July 27, 2023

Re: SP23-003, "Hidden Valley PRD", Technical Review 1
Location: 12527 51st Ave NE

RE: Hidden Valley Short Plat, File# SP23-003
5 lot preliminary short plat/PRD on 1.24 acres
12527 51st Ave NE & Parcel # 30050300302600

**SEWER &
WATER
PLAN**

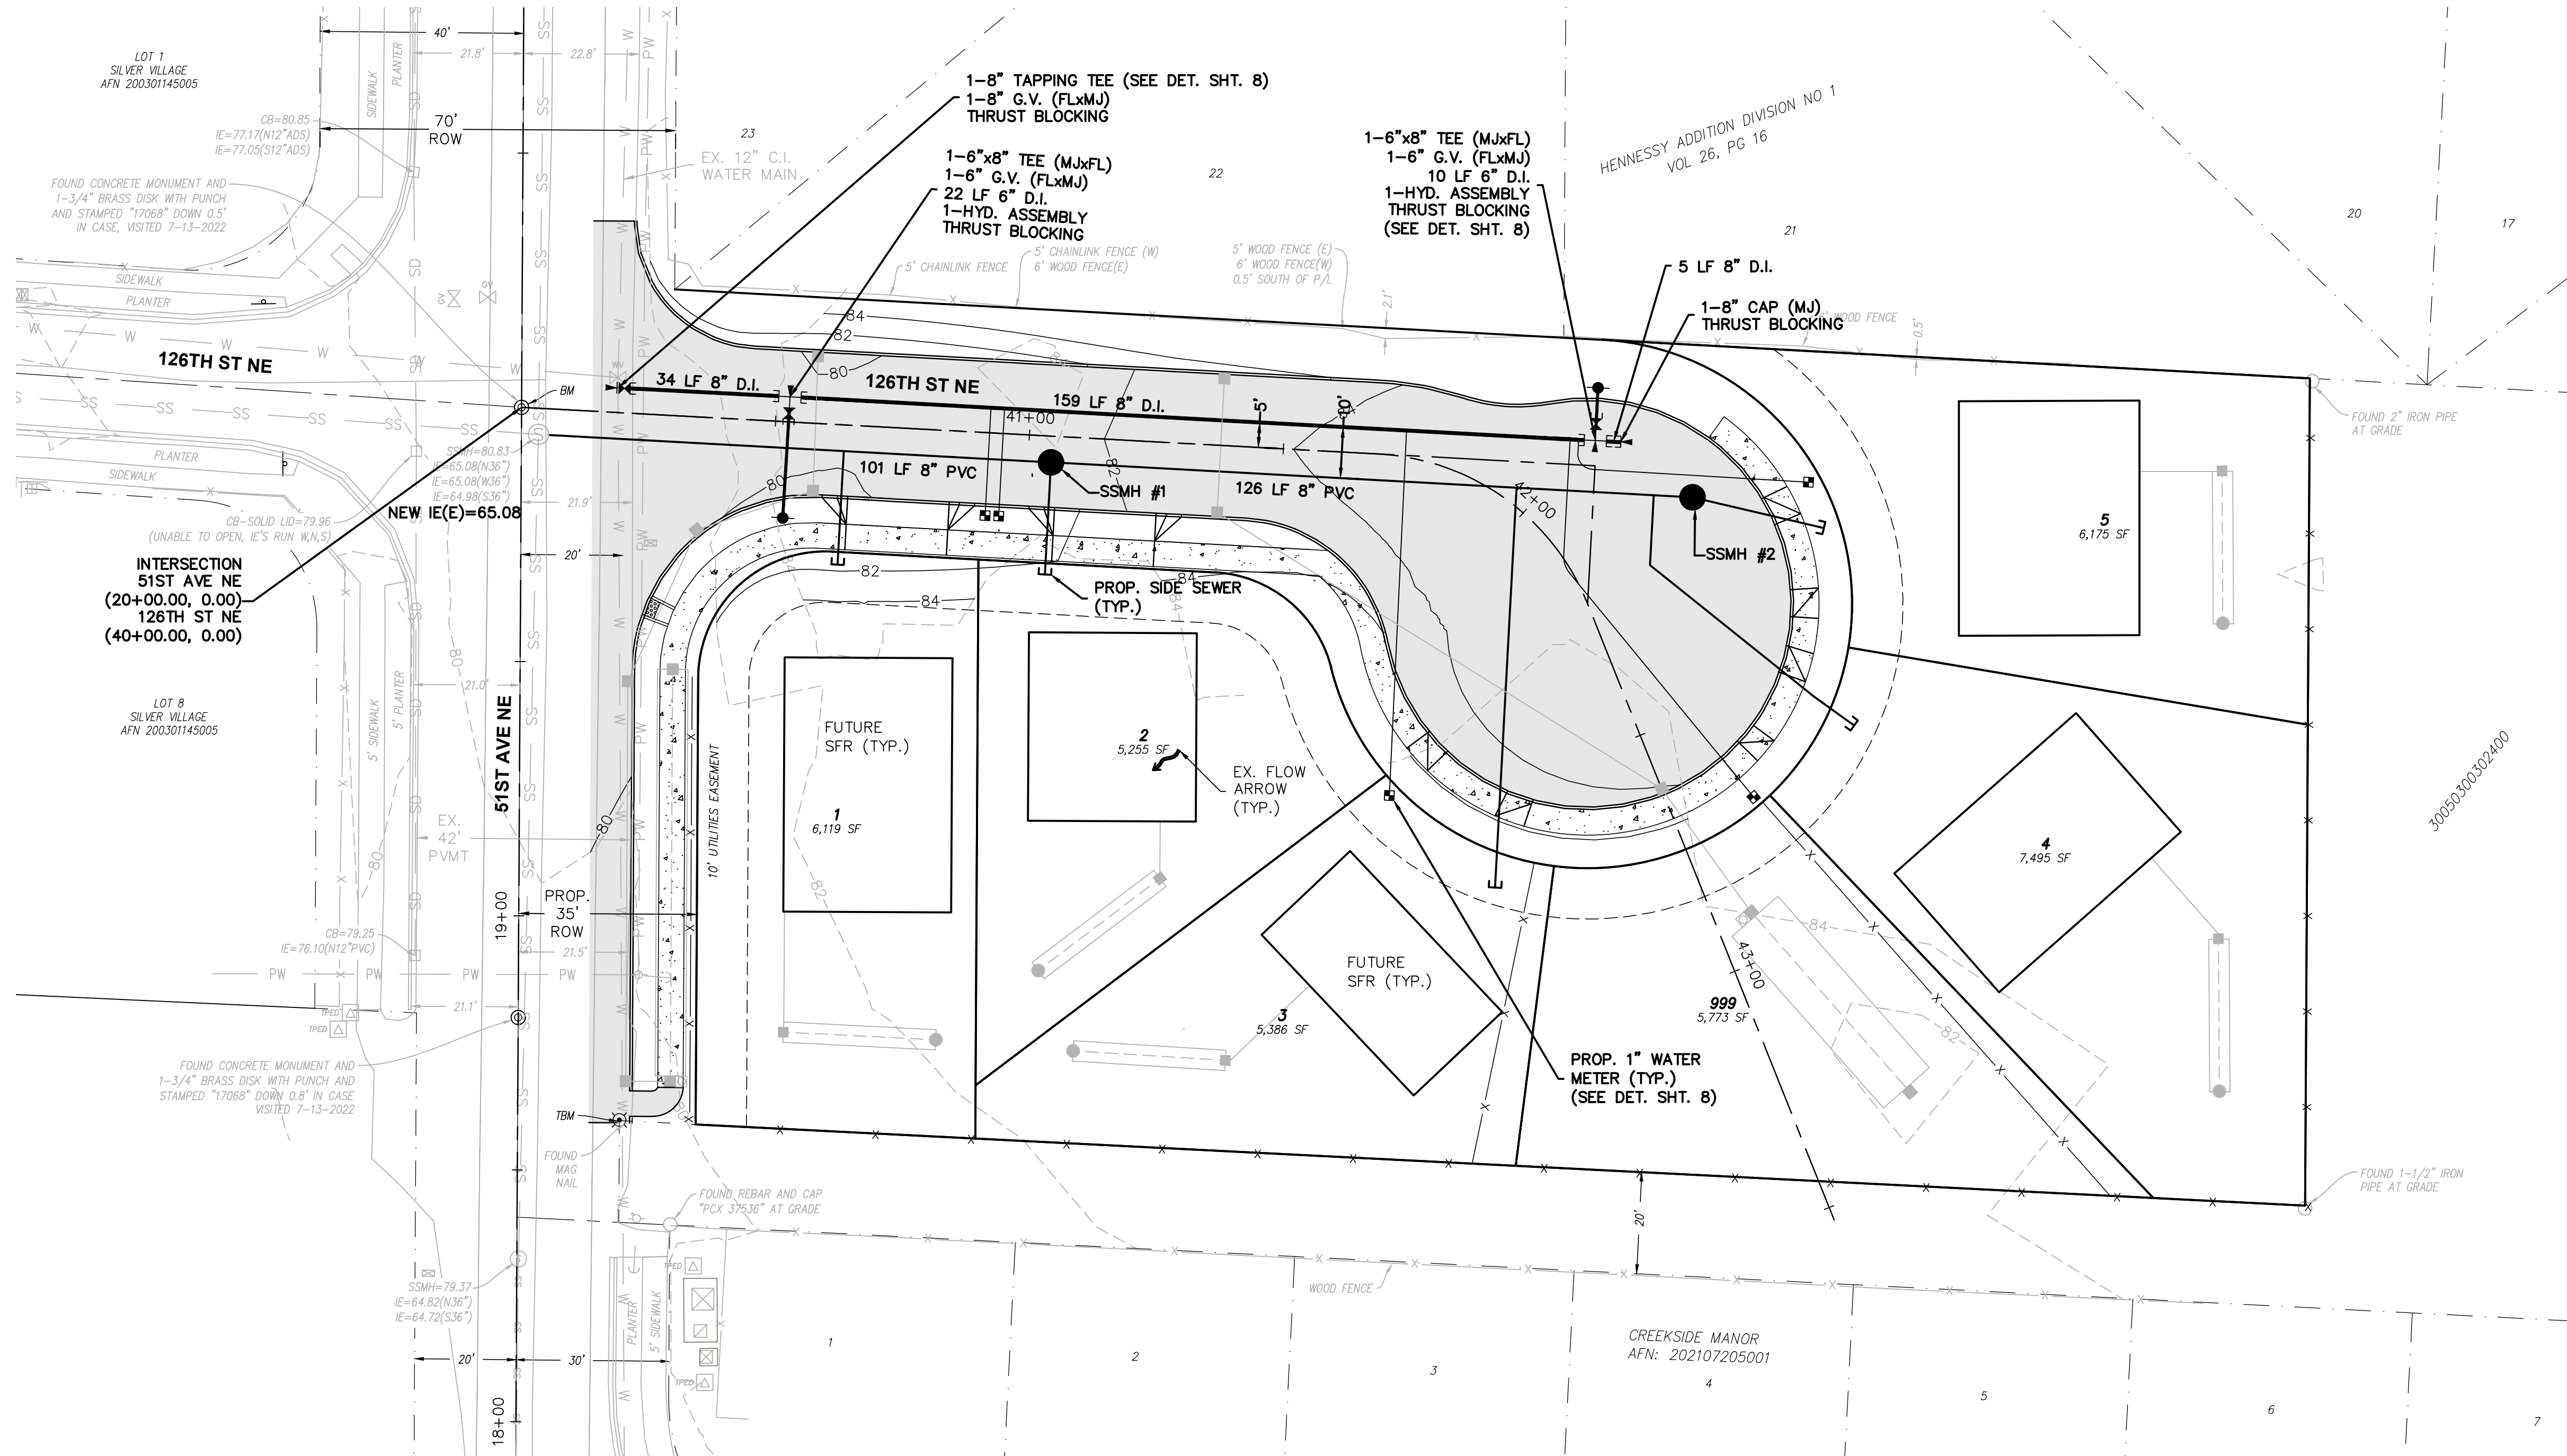
1. Water details not shown;
2. End of new water main will require a 2" blow off assembly;
3. Tie in on 51st Ave NE will need to be a live tap;
4. Relocate hydrant assembly to behind sidewalk.
